From: Laura Mephram
Sent: 04 March 2025 14:27
To: Nick Hirst
Subject: RE: S73s at Crossley (2024/92774, 2024/92775, 2024/92776)

The plans attached to this email relate to Parcels 1 & 3 – Ref - 2024/92776.

DRAWING:
3B.R1 - AS
STONE
PLANS & ELEVATIONS

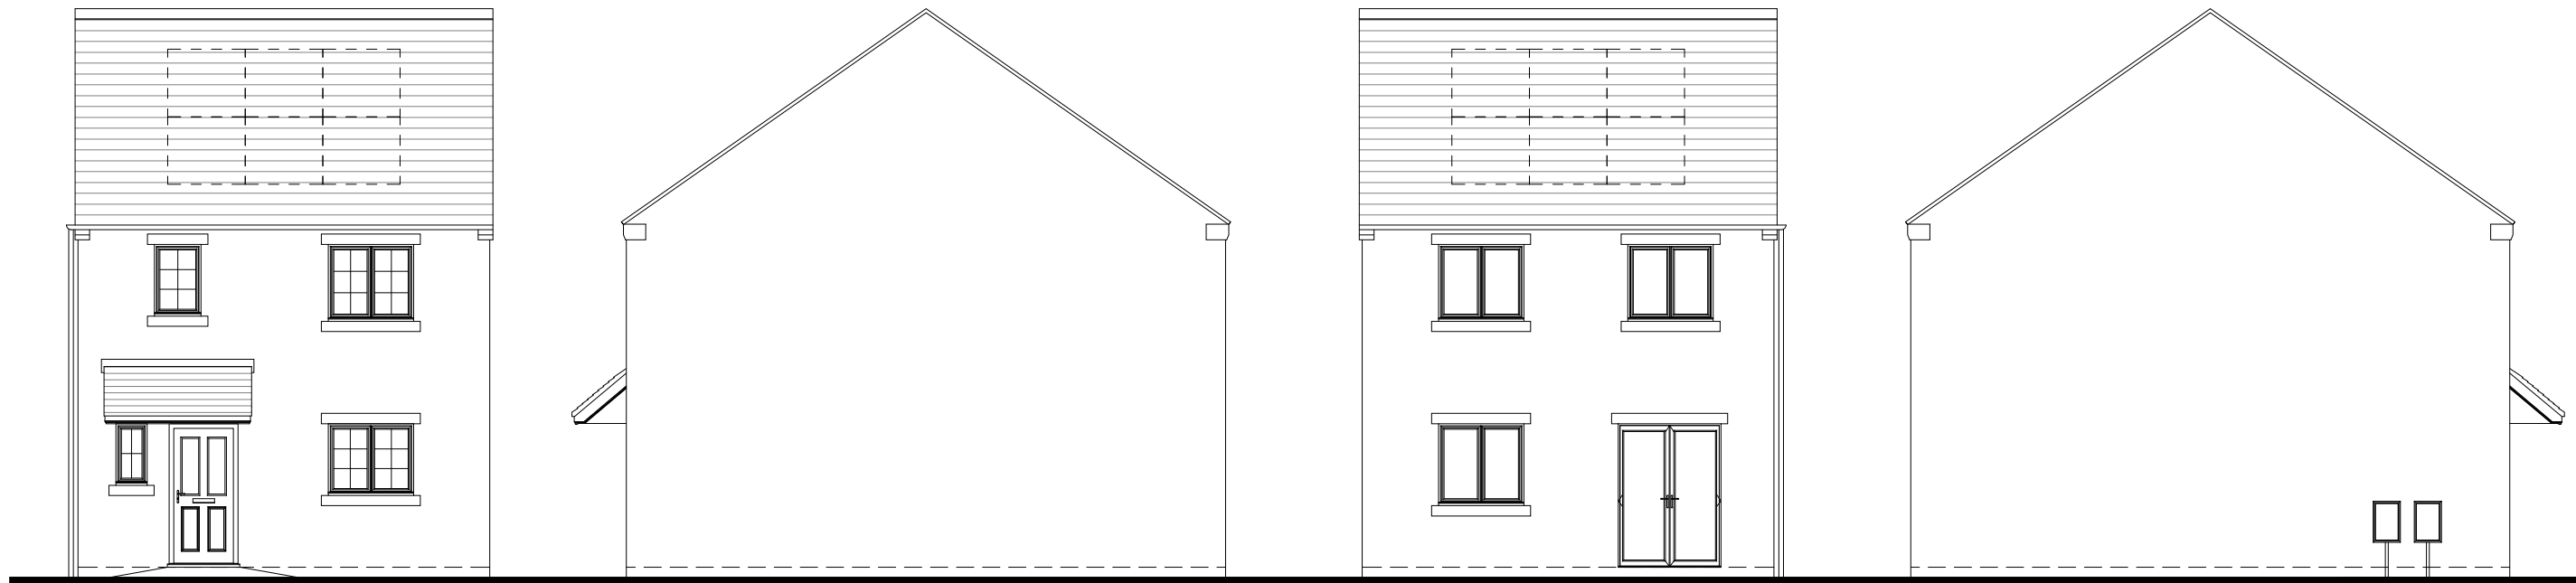
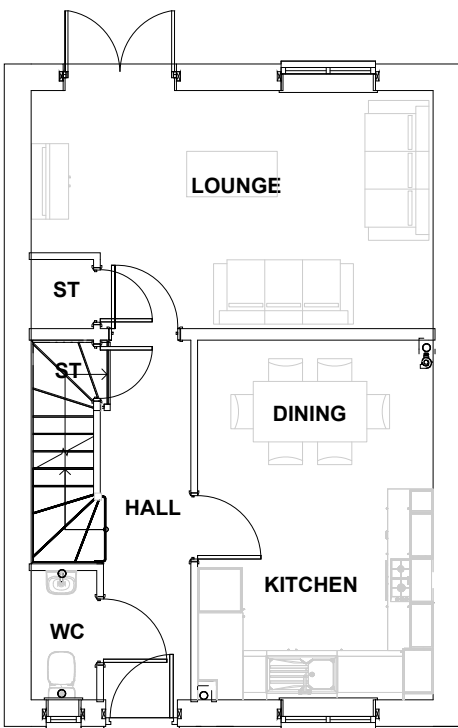
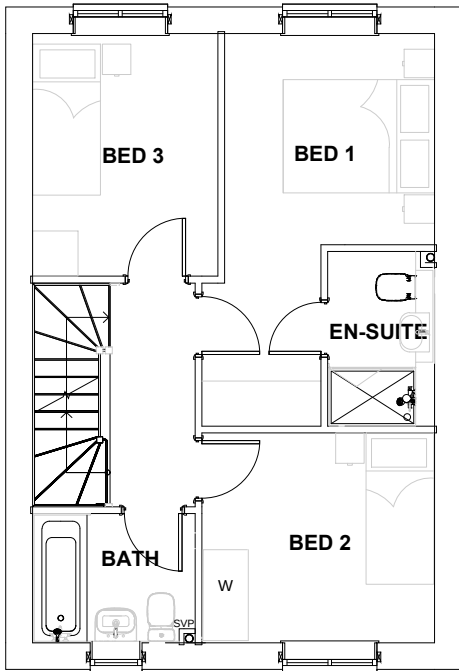
- Solar - Indicative solar panels are shown to the roof plans

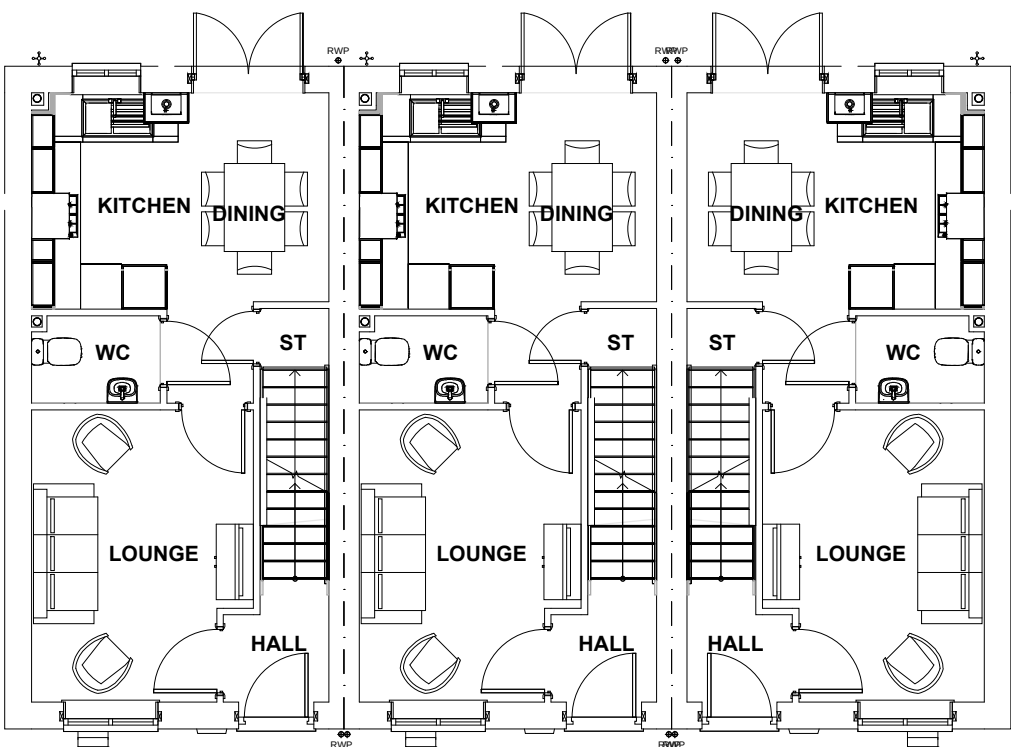
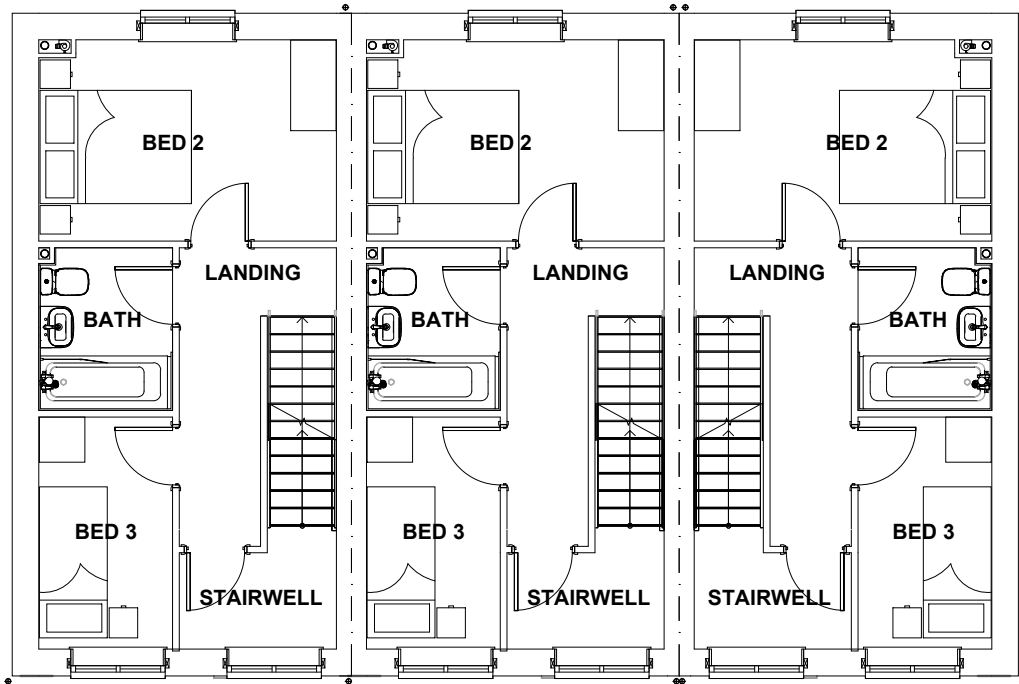
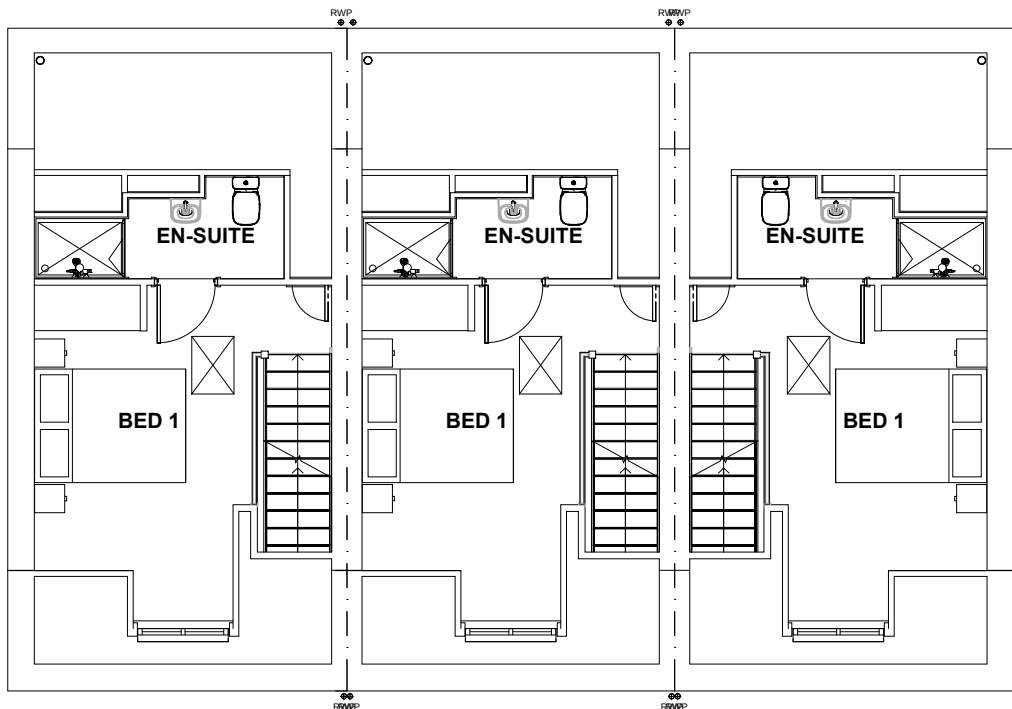
- All flat roof dormers have been replaced with a pitched dormer.
- Heads and cills have been added to front and rear elevations
- Rendered units on the site's frontages swapped to the approved (art) stone
- Meter boxes relocated to side elevations where possible.
- Parcel 4 – Plots D1 and D2 as submitted were a pair of semi-detached, as requested this has been amended to reflect the consented layout with a Type P proposed, which is art stone. Plots D44-52 have been revised to maintain the overall plot numbers on this Parcel at 52.
